associated  
earth sciences  
incorporated

Project No. 20180261E001

Subject: Response to City Comments  
Chen Residence  
5024 West Mercer Way  
Mercer Island, Washington

Geotechnical Report: Subsurface Exploration, Geologic Hazard, and  
Geotechnical Engineering Report  
Chen Residence  
Mercer Island, Washington  
Dated September 20, 2018

A102

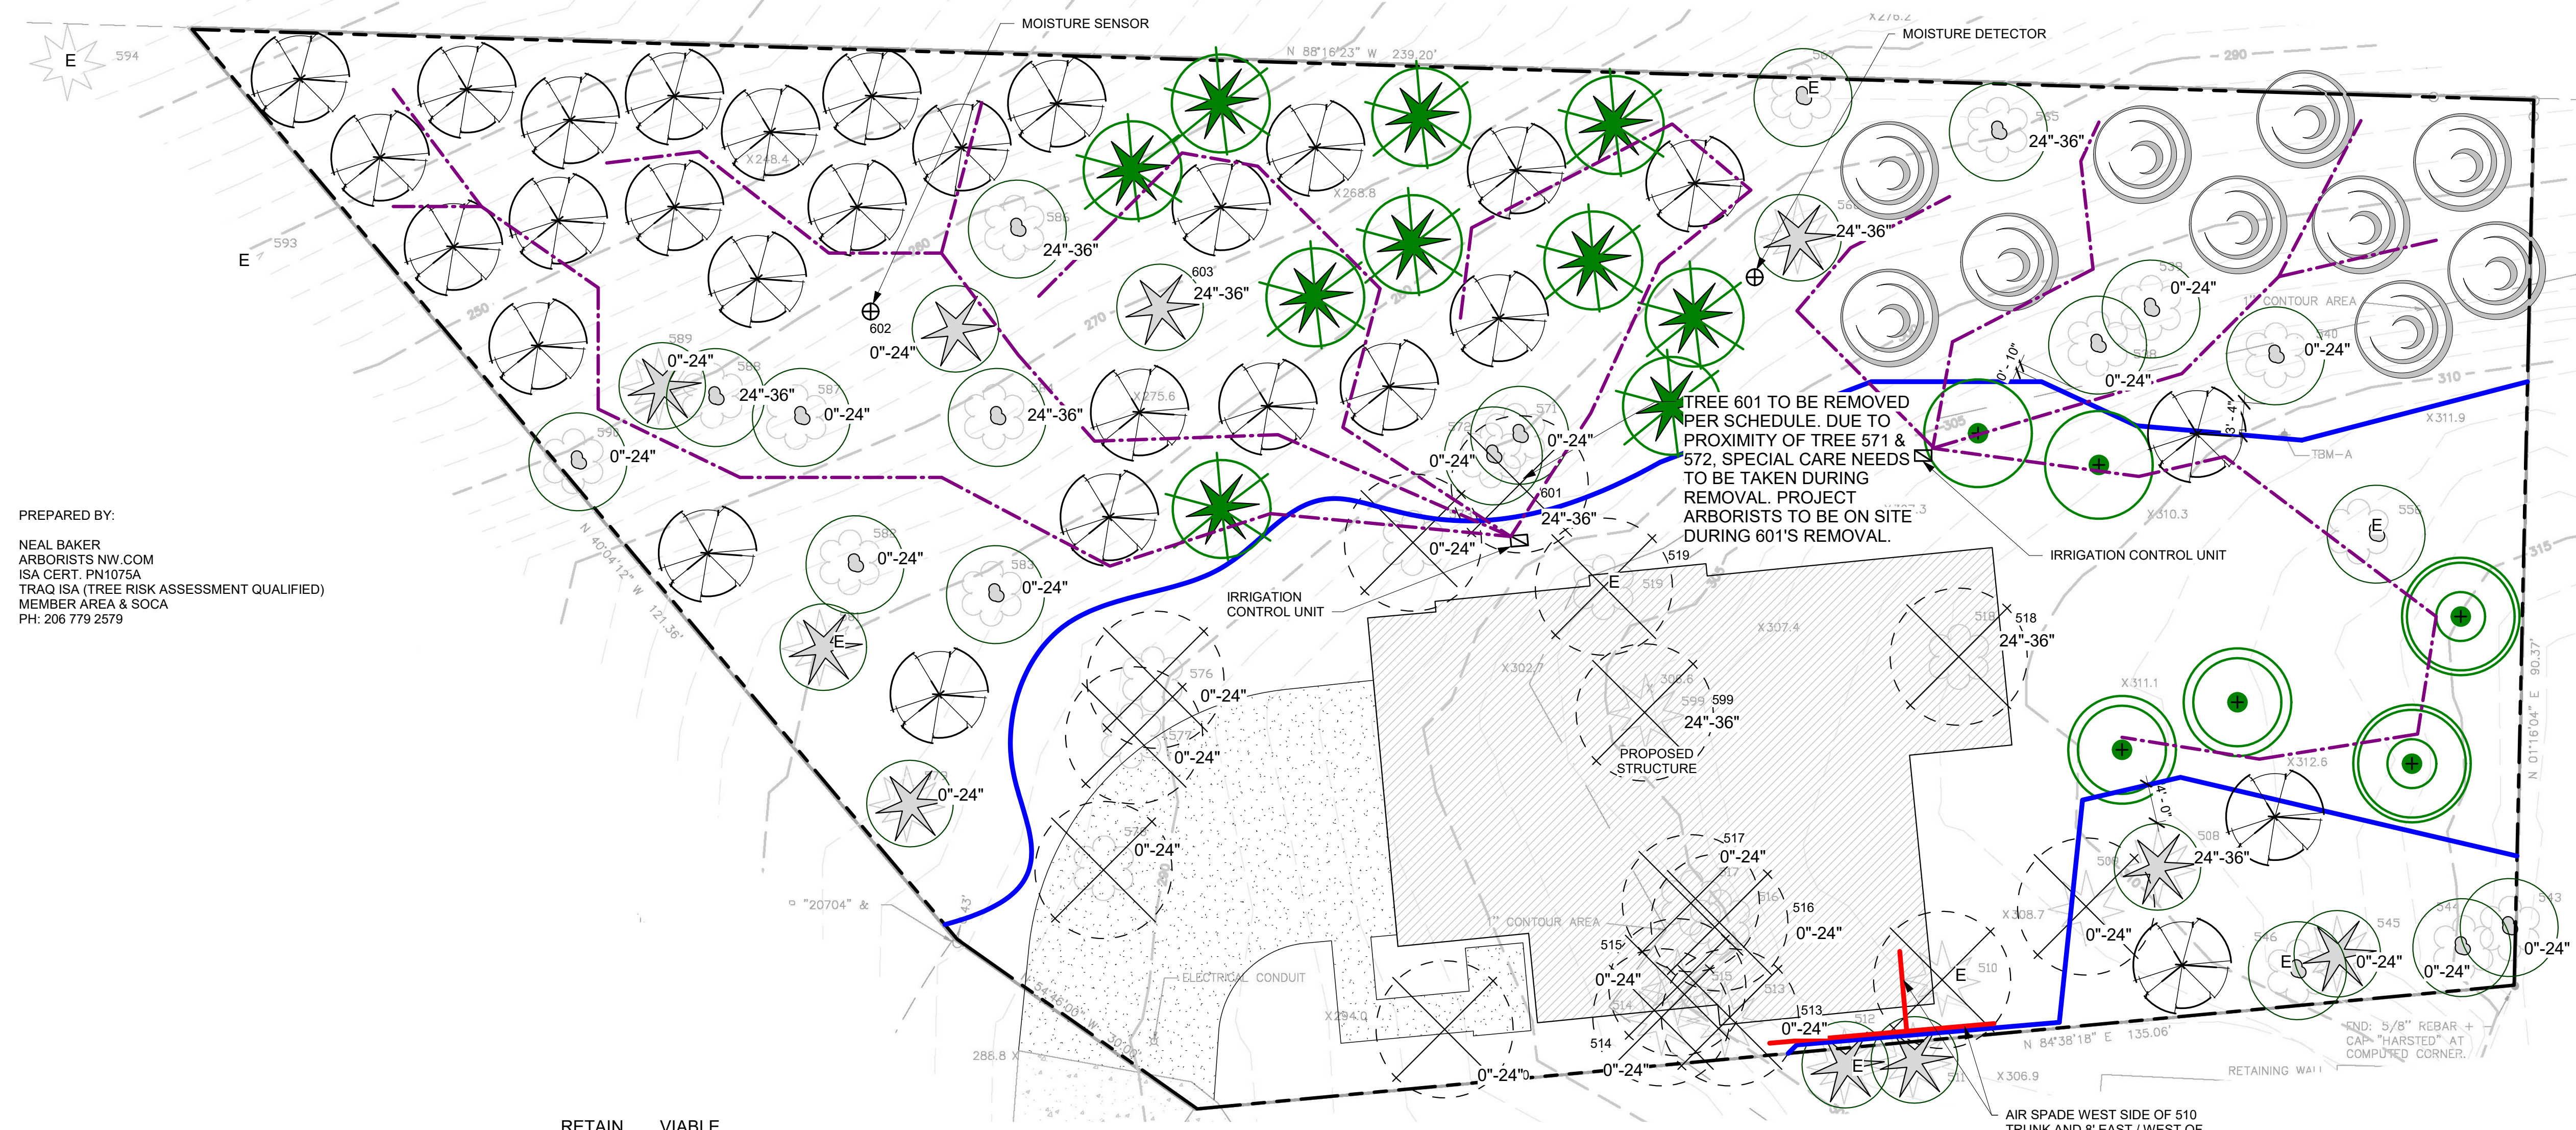
*Geotechnical engineer to review location/depth of proposed footings along the south side of the structure with respect to anticipated temporary cuts required for construction of the foundations. Verify that temporary cuts do not encroach onto the adjacent property as well as identify potential impacts of temporary cut to existing structure located upslope. Provide*

*recommendations to mitigate potential impact to existing structure above or shoring recommendations if open cut excavation will encroach onto adjacent property in a letter addendum format for review.*

Review of the temporary excavation plan presented on Sheet A102 indicated that the proposed temporary excavation for the residence should remain within the subject property.
